From:
Sent: 21 September 2023 09:24
To: DCAdmin
Subject: Planning objection 17 Grosvenor Road, Batley, WF17 0LN - 2023/92400

Planning ref 2023/92400 - 17 Grosvenor Road, Batley, WF170LN

I would like to register my objections to the proposed rear and side extension to 17 Grosvenor Road, Batley which lies within the Upper Batley conservation area due to the following reasons.

Revisions	Date	Aug 2023	Planning Application for:
			Proposed Rear & Side Extensions
			17 Grosvenor Road, Batley
			Drawing Title:
			Proposed Plans and Elevations
			Drawing No: S04
			Rev B
			Scale: As shown Paper Size: A0

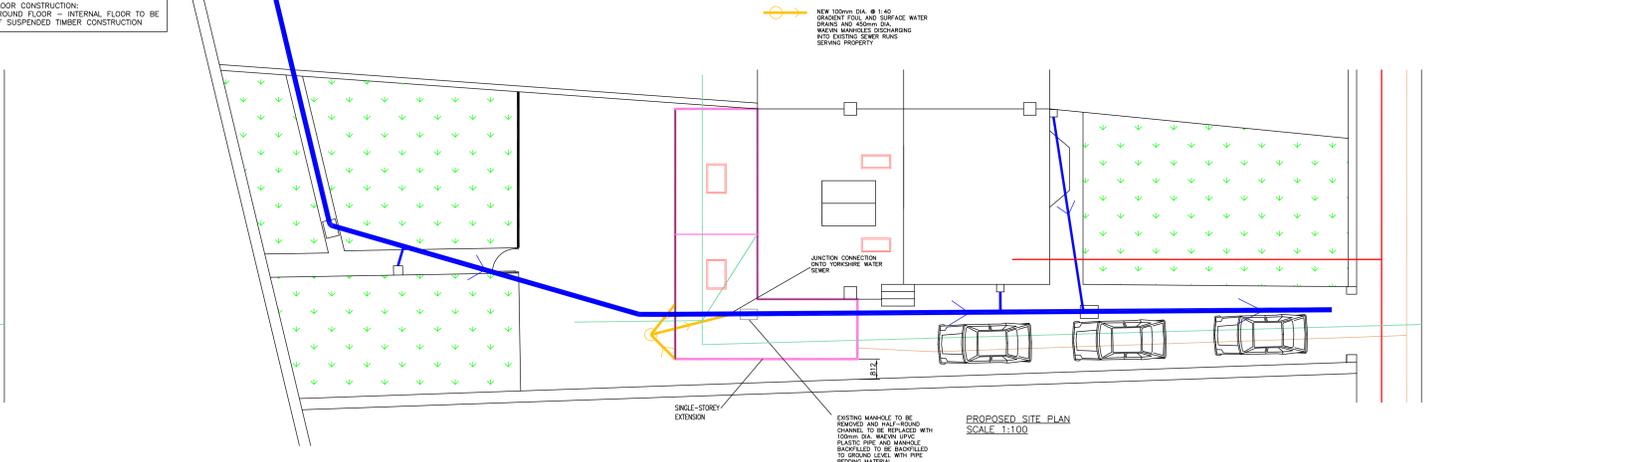
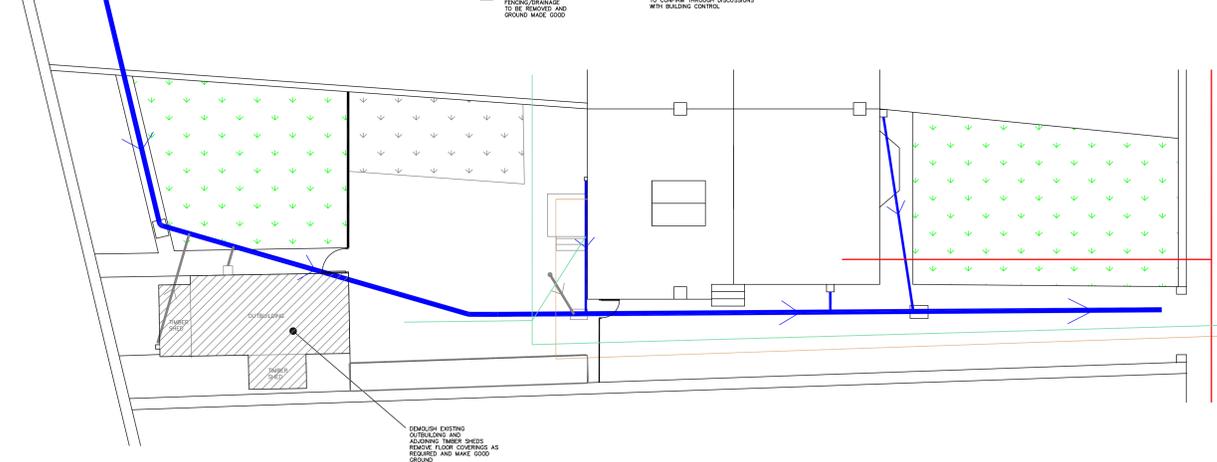
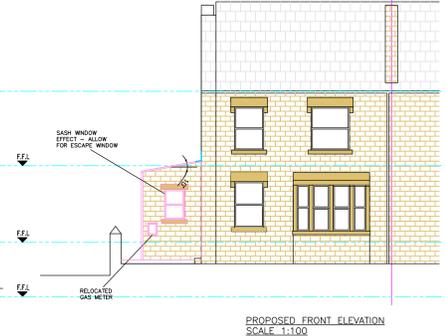
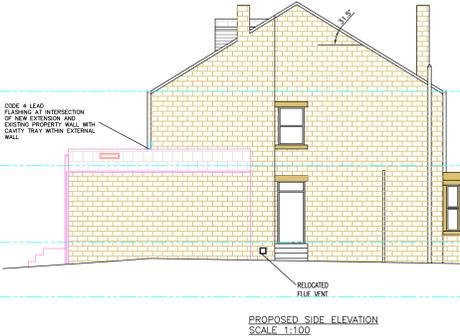
- 2- The proposed rear extension projects 3.3m from the rear elevation which exceeds the maximum permitted 3.0m also the ridge height is 4.5m, as both dimensions exceed the guidelines of the House Extensions and Alterations SPD being 3.0 and 4.0m respectively. It would not be accepted under a large extension application also due to the increased eaves height of 3.6m and ridge height of 4.5m, it is also a wraparound extension again not meeting guidelines.

- 3- The proposed rear extension is shown as being built up to the boundary line to no19 taking no account of the existing dividing fence. The properties also have a basement level to the rear which will result in a deep foundation being required which will cause potential collapse of the rear yard to No19 and the retaining wall to the boundary of No15. The new foundation to the boundary of No19 will also project over the boundary line with the toe projection from the wall. Once again, the House Extensions and Alterations SPD states that a minimum of 1.0m should be maintained from the boundary.

- 4- The proposed extension being built close to the boundary of No19 will also cause a rainwater discharge problem as no external gutter will be fitted as it would project over the boundary line. A convoluted gutter as shown in Detail 1 is proposed but this would not prevent water runoff being discharged directly over the boundary line on to the ground.

- 5- The final objection is the overshadowing caused to the rear elevation lounge window of No19. With the larger projection from the rear wall of 3.3m and the raised eaves height of 3.6m being so close to the boundary extensively fouls the 45 deg splayed line. This together with the orientation of the properties will cause a substantial loss of light whilst also creating an overbearing feeling to the garden area and lounge room. The 3.6m eaves to the boundary of No15 will also cause an extreme overbearing feeling as the external ground level is stepped down, with No17 being some 750mm higher thus exaggerating the height of the extension to some 4.4m high within 800mm of the boundary line which will affect the 2no windows to side elevation of No15 which at present are shaded by the existing dwelling.
